From: Susan Leeson [REDACTED]
Sent: 31 August 2021 08:58
To: Simon Davis <Simon.Davis@arun.gov.uk>
Subject: RE: Brookview Nursery WA/58/21/PL

Subject: RE: Brookview Nursery WA/58/21/PL

Proposed Block Plan
Scale 1:500

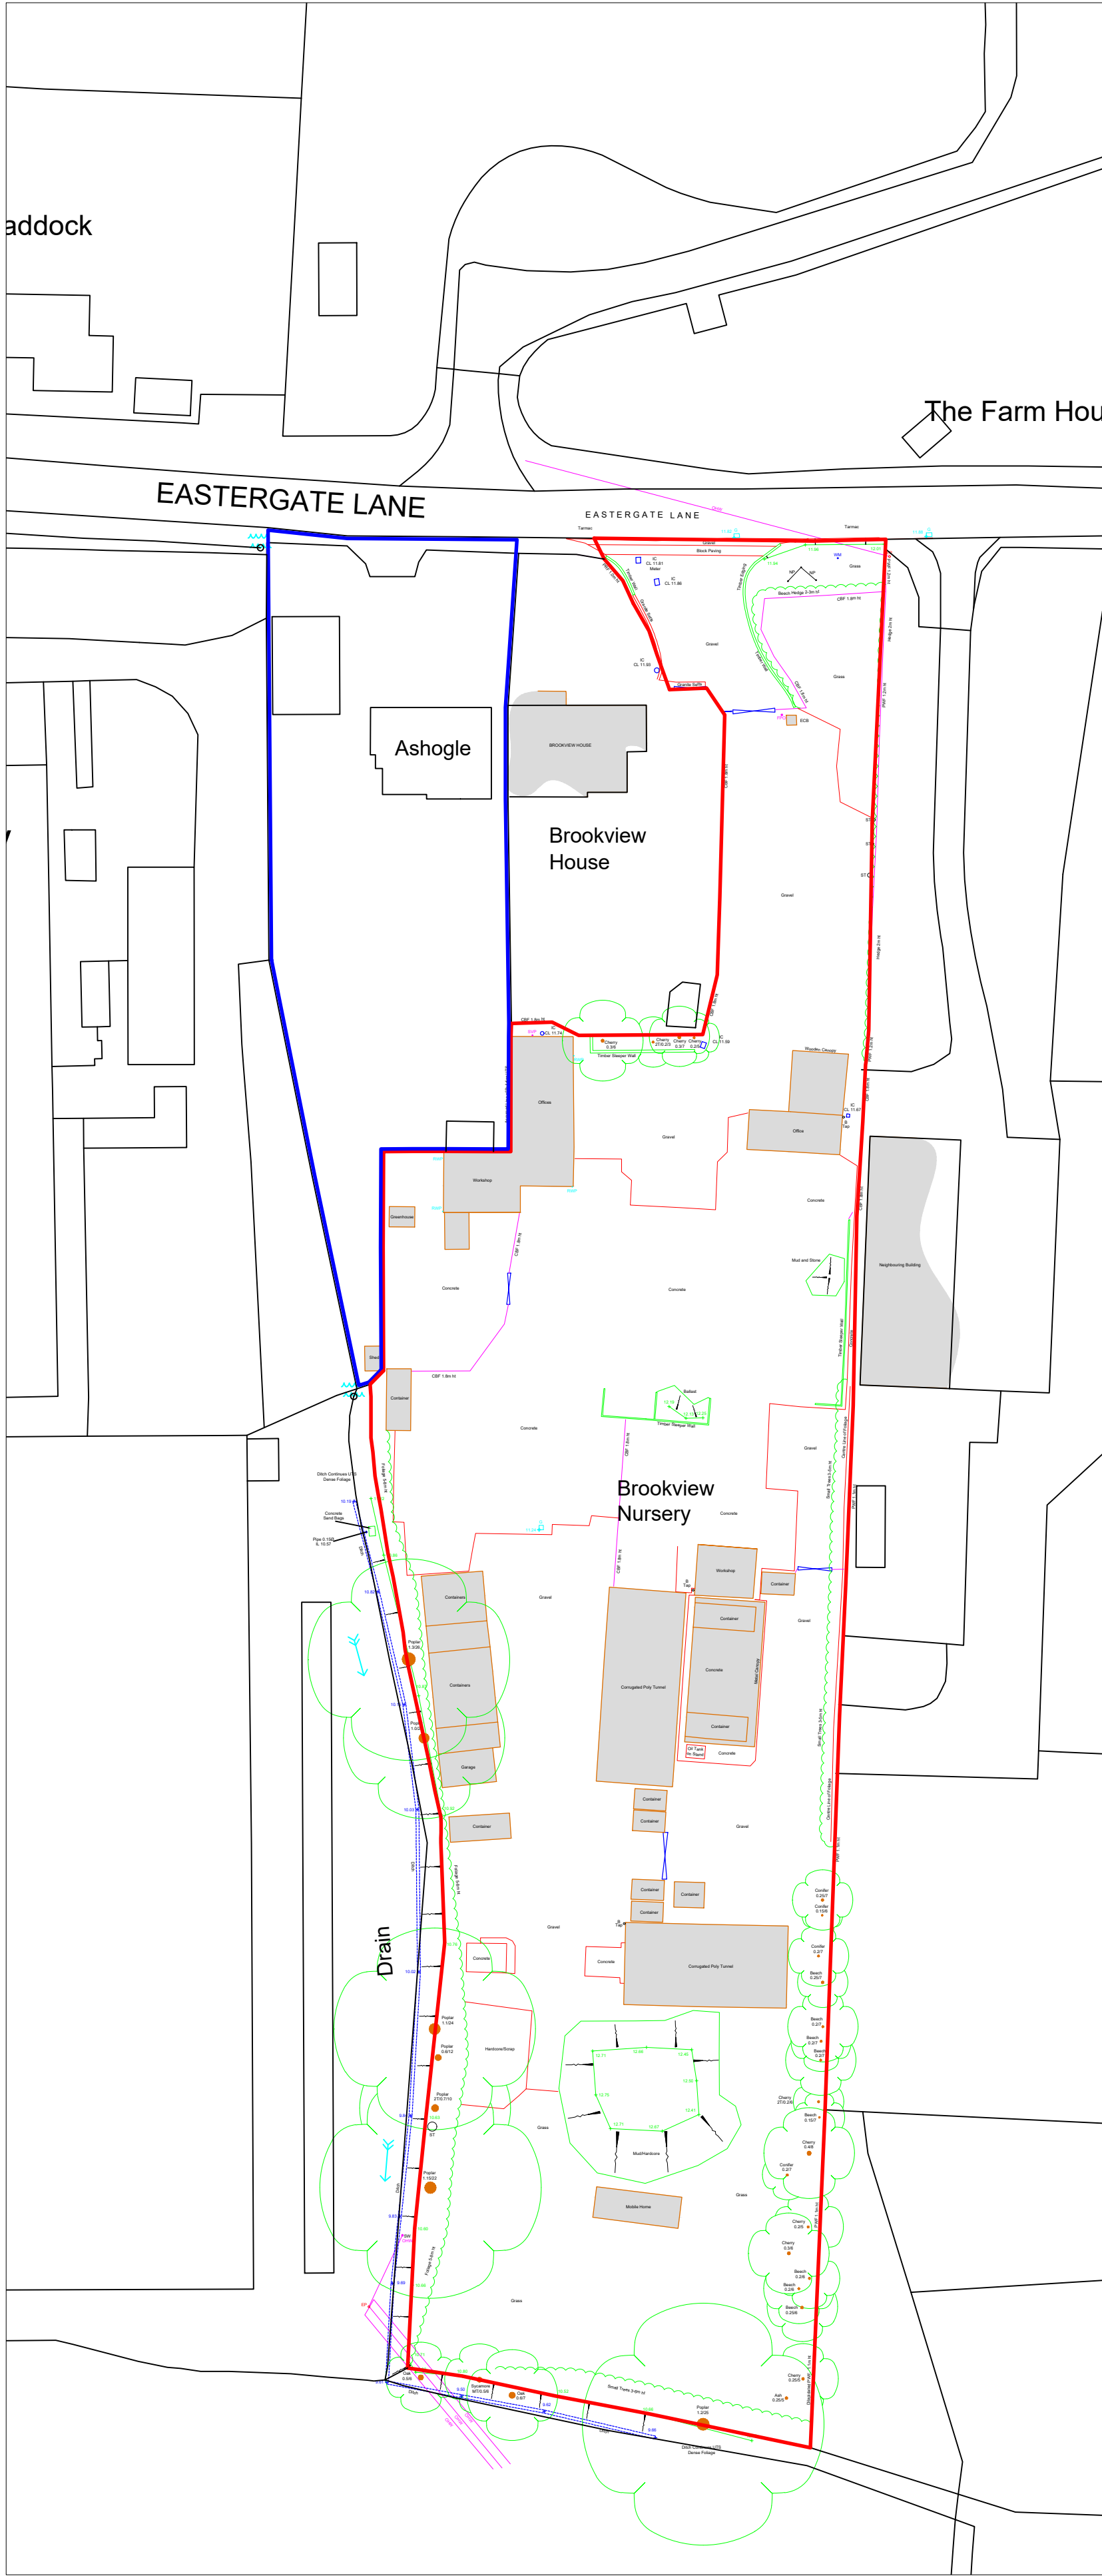
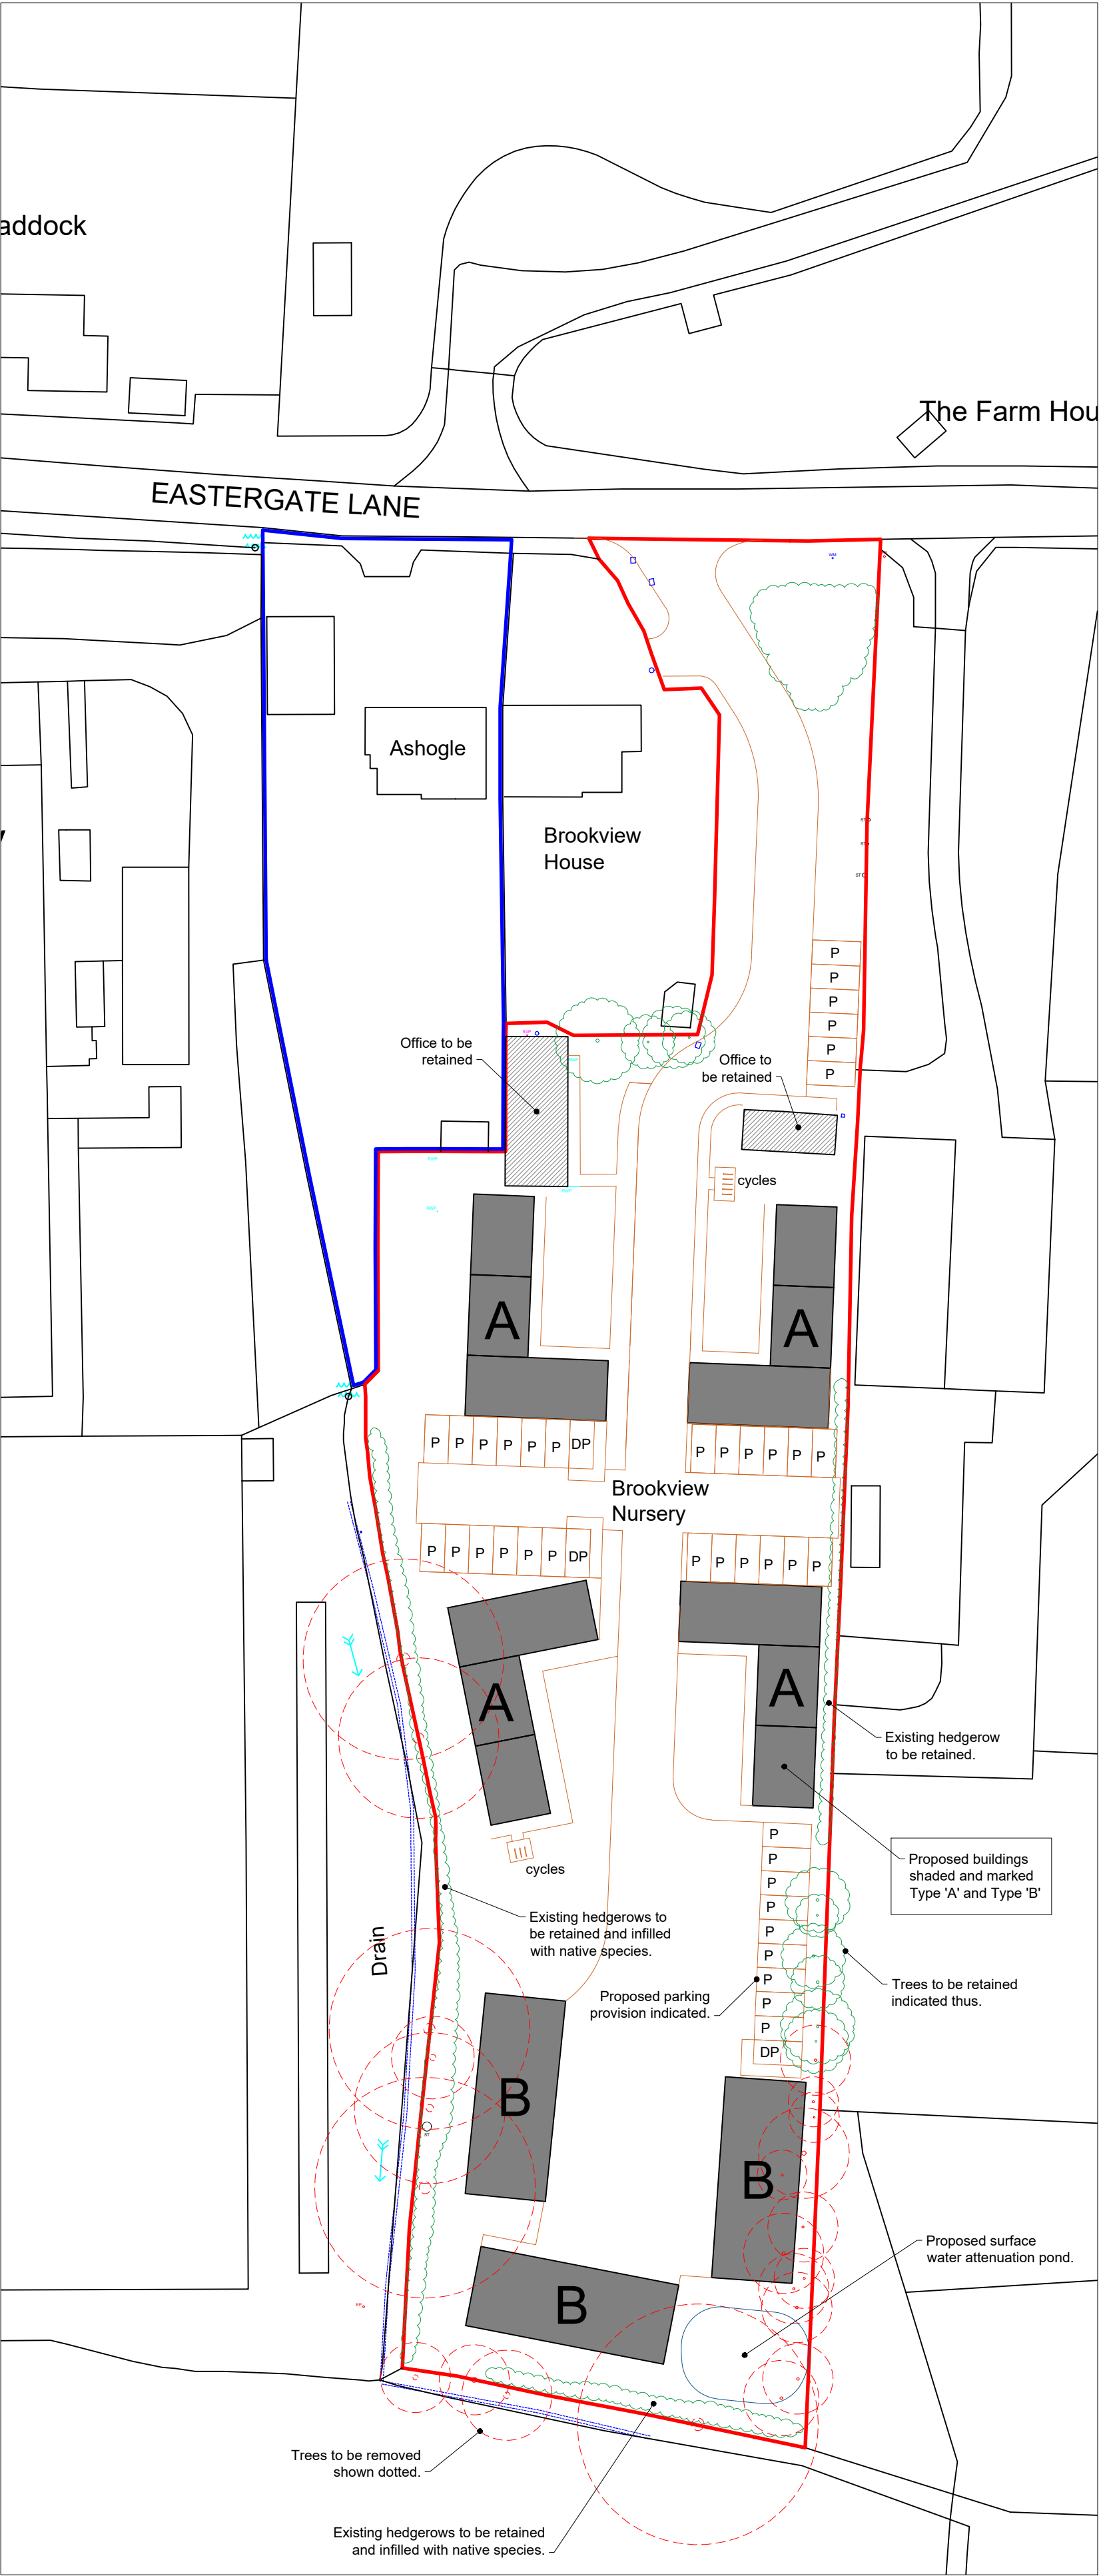
Anyway, I note that you are proposing to remove trees along the western and southern boundaries and so I think you would be in conflict with policy VE10 which states:

Proposals will not be supported where there is evidence that the proposals would significantly harm biodiversity, unless it can be adequately avoided, mitigated, or alternatively the subject of compensation. Where proposals have an impact on Biodiversity rich habitats, a management plan shall be provided to ensure that the long-term protection and enhancement of the habitat can be achieved.

This conflict is likely going to make this very difficult to get through the DC Committee. You may be able to resolve this by layout changes/biodiversity net gain proposals.

Further speaking of which, you have not provided any tree survey so we cannot assess the impact on trees. I have consulted the Tree Officer but if he does respond, he will only say that no tree survey has been provided. Sorry for not spotting this previously but this does need to be provided.

Further update, the ecology and tree survey will be undertaken today, which will also address the wildlife corridor.

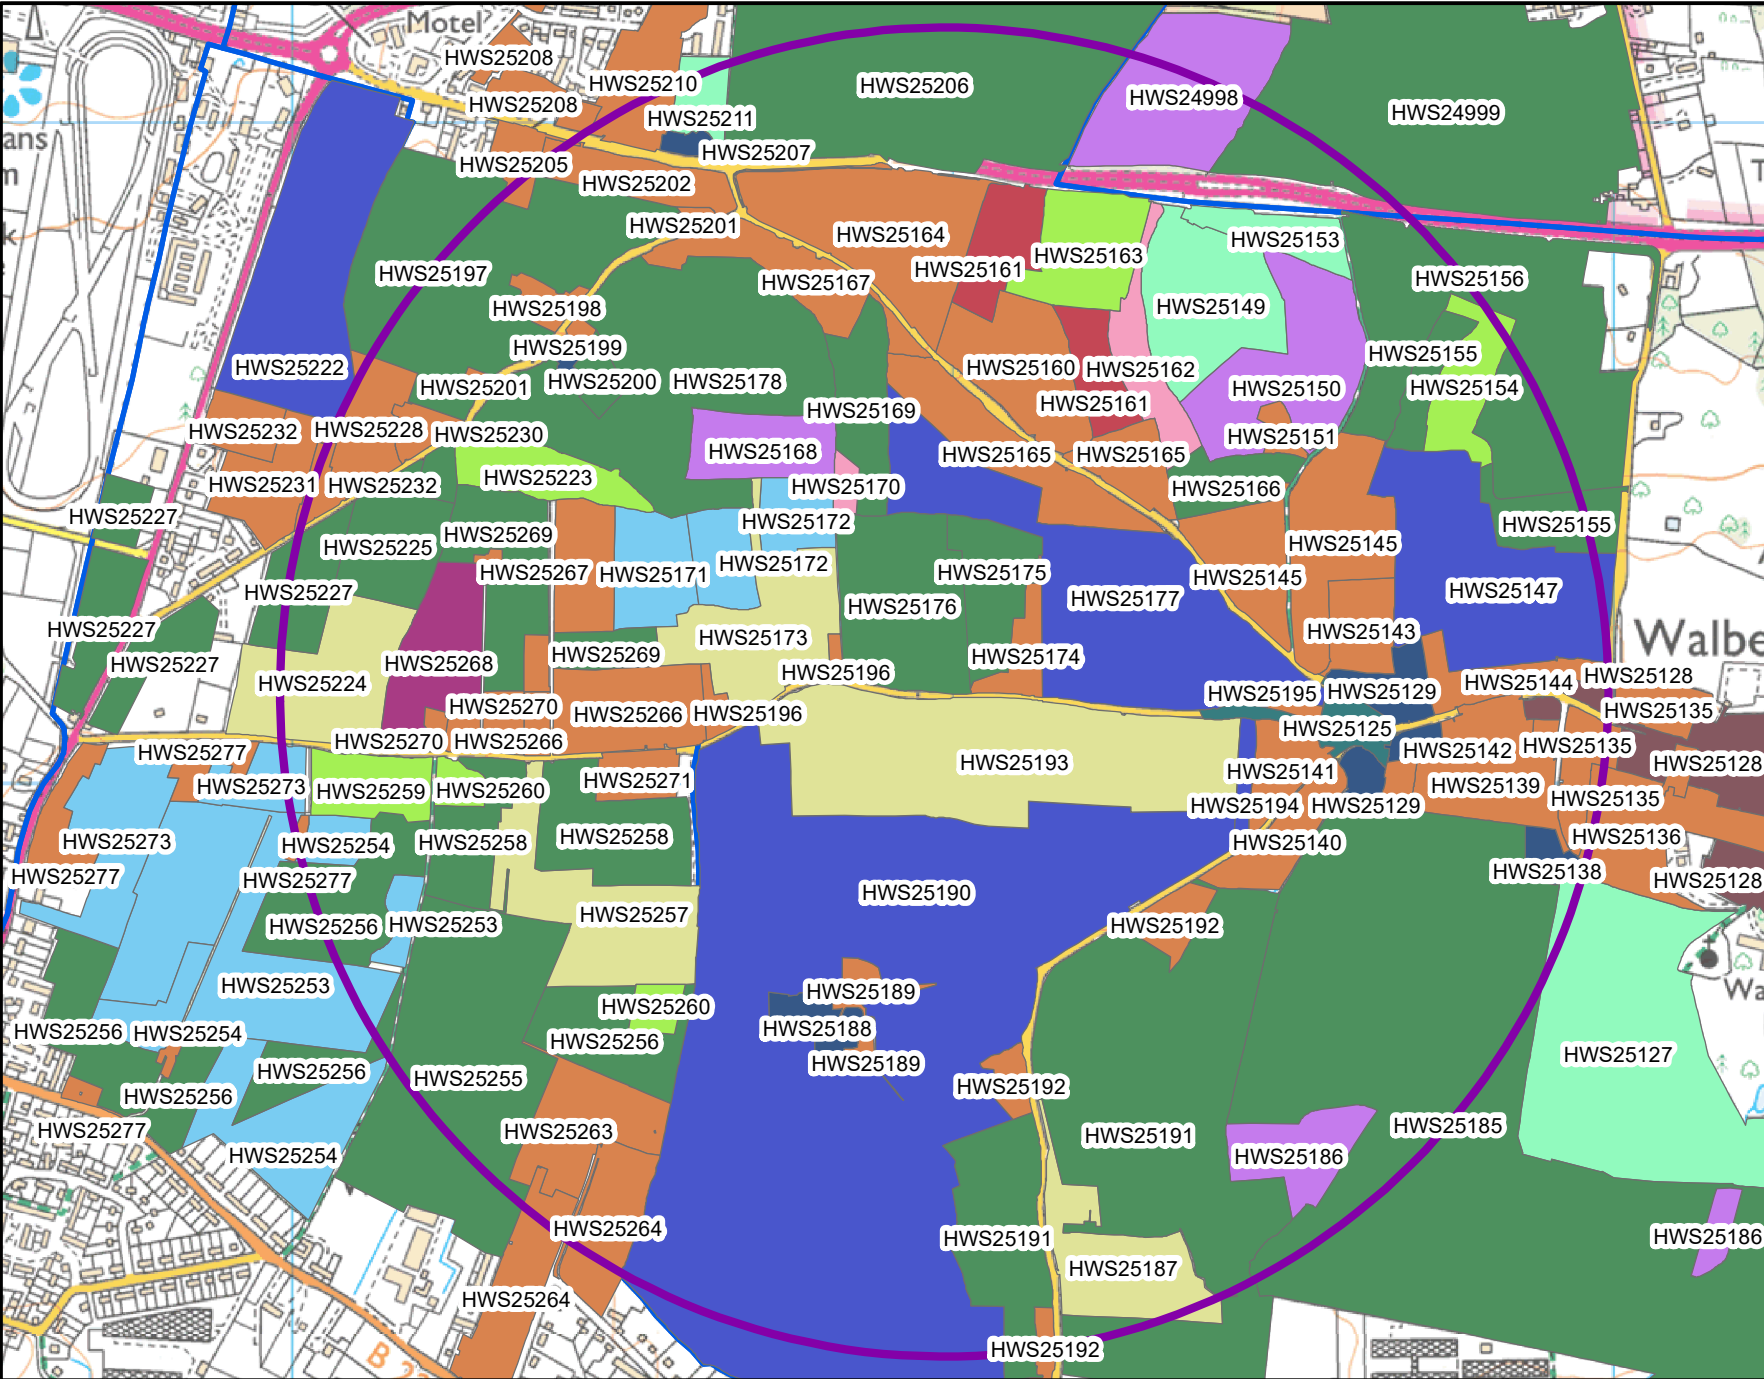
The WNP also has a new biodiversity corridor policy. One of these is Wandleys Copse and the WNP suggests that it goes through your site (see green line below). It probably actually goes down the western side and then along the southern end following the line of the ditches before heading south again but the WNP shows it going through the site and so without clarification, I have to deal with it as shown. If you want to query this, I suggest you speak with the Parish.
